Our Case Number: ABP-313182-22

Re: BusConnects Clongriffin to City Centre Core Bus Corridor Scheme
County Dublin

Clongriffin to City Centre Core Bus Corridor Scheme

Image 3.7: Alternative Options between Griffith Avenue and Clontarf Road

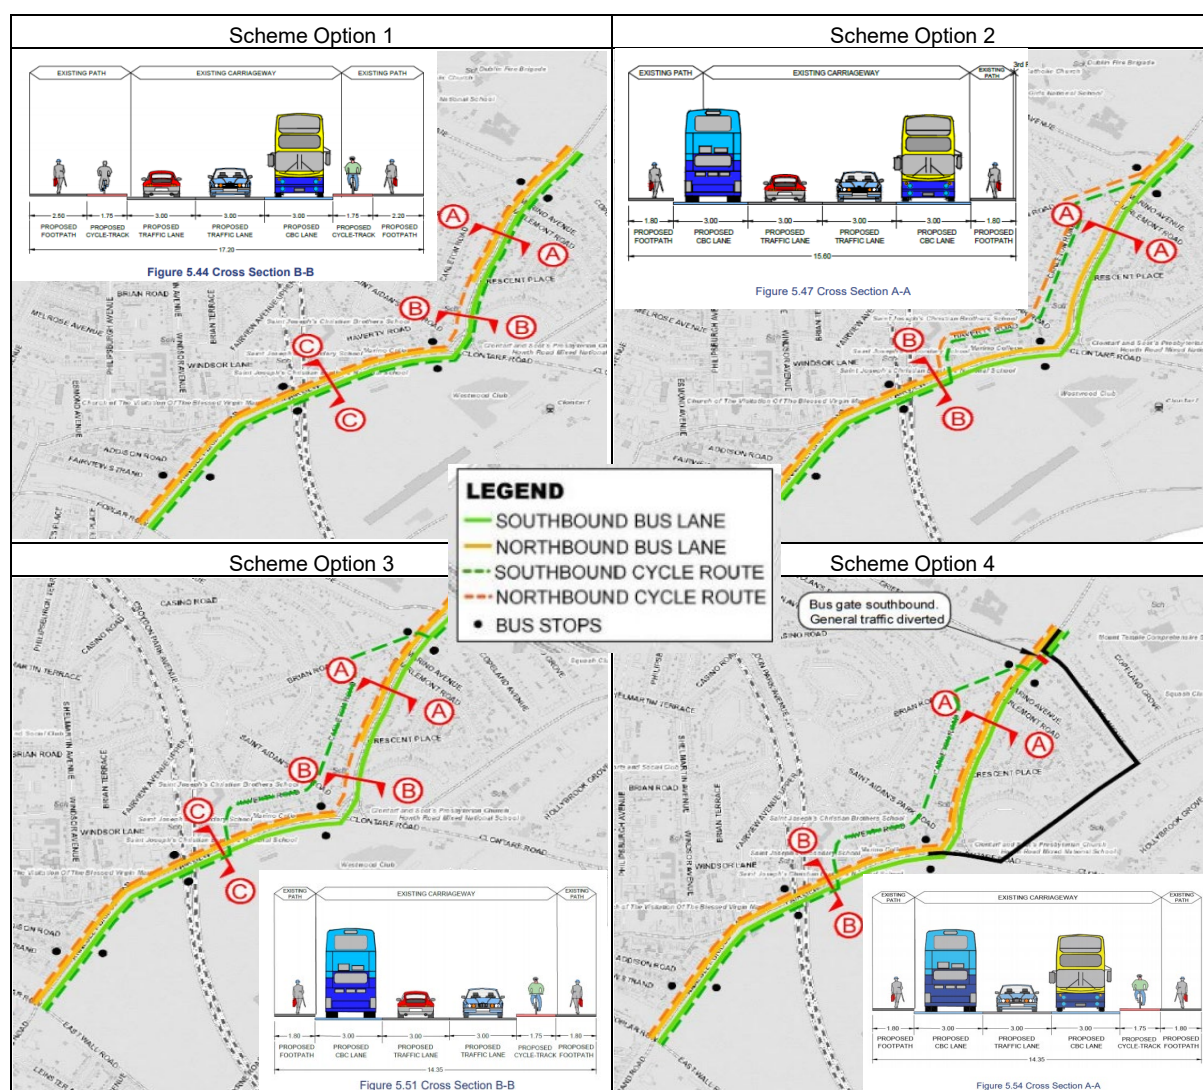
I am only a very occasional cyclist, but in considering off road tracks, you need to consider whether cyclists will just use the bus lane instead. This is acknowledged in the documents, but regrettably I don't think there is any attempt to analyse it. Given that the inbound off road track at Brian Road requires a complex crossing of the road at both Griffith Avenue and Fairview and given that I suspect the Malahide Road is sloping downwards towards Fairview,

I suspect that most cyclists will just use Malahide Road towards the city. The off road track will be disruptive for Brian, Carleton and Haverty Roads and in assessing whether it should be permitted as proposed, I think it could be assumed that there may be little inbound use.

6.7
Flow Difference on Road
Links 2028 Opening Year
DoMinimum vs DoSomething
AM Peak Hour

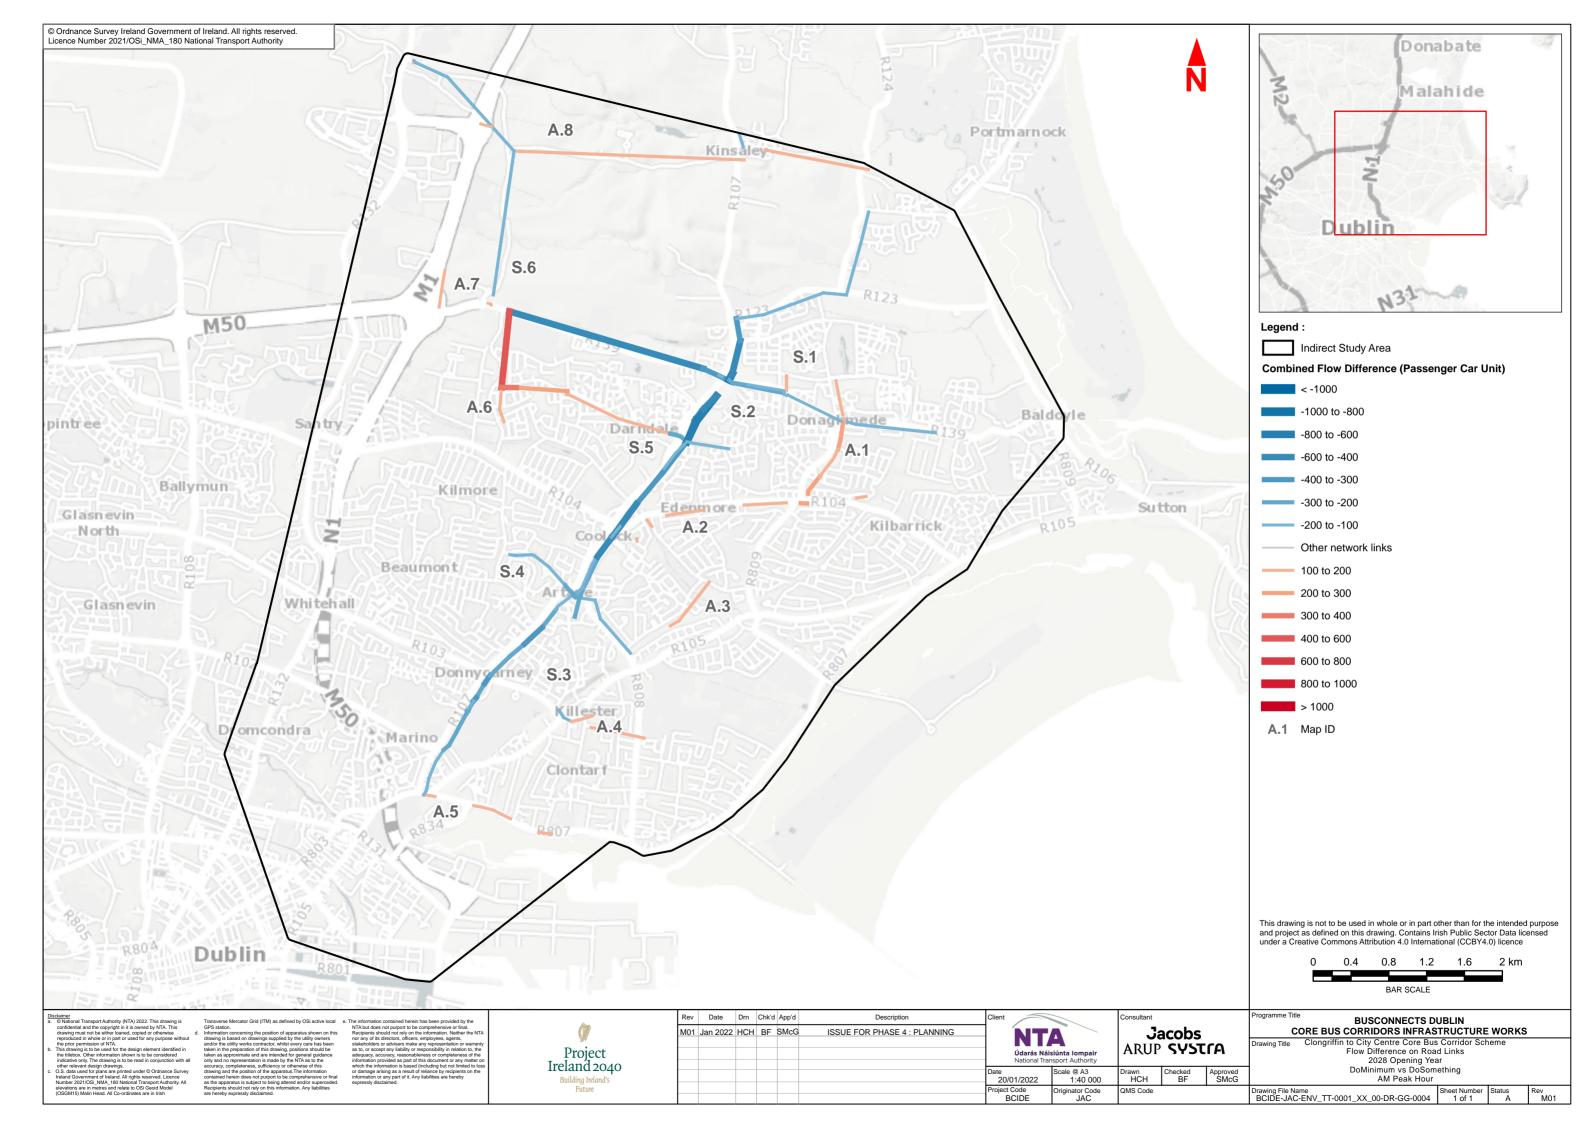
The maps in the traffic reports in chapter 6 identify a number of roads which apparently will have very material extra traffic in 2028 at either or both AM and PM peak. Examples include (pages 93 and 97)

Clonshaugh Road A6 818 to 1288 AM also PM increase
Clonshaugh Avenue A6 243 to 564 AM
Priorswood Road A6 245 to 427 AM
Vernon Ave A4 207 to 333 AM
Kilmore Road P6 717 to 992 PM
Oscar Traynor Road P7 349 to 626 PM
Baskin Lane P10 882 to 1239 PM

I have to say I find it difficult to see why a scheme, which allegedly diverts a lot of passengers to bikes and bus and which leaves a single lane available to general traffic each way, can possibly have the impact suggested on local roads a fair distance away. It seems however to be very bad practice for them to indicate at an obscure point in very complex documents that there may be a knock on effect on a distant road that is material, without any requirement to notify residents of that road that the Clongriffin scheme impacts them adversely. I note that while soothing statements are made about roads with traffic reduction such as "positive, moderate and long term effect", no statement is made about roads forecast to have more traffic. While there is a lot of stuff about junctions at those roads apparently being able to cope with extra traffic, the extra traffic on the actual roads is a serious loss of amenity for residents

It is not clear whether these figures include the cumulative effect of the Swords Road corridor.
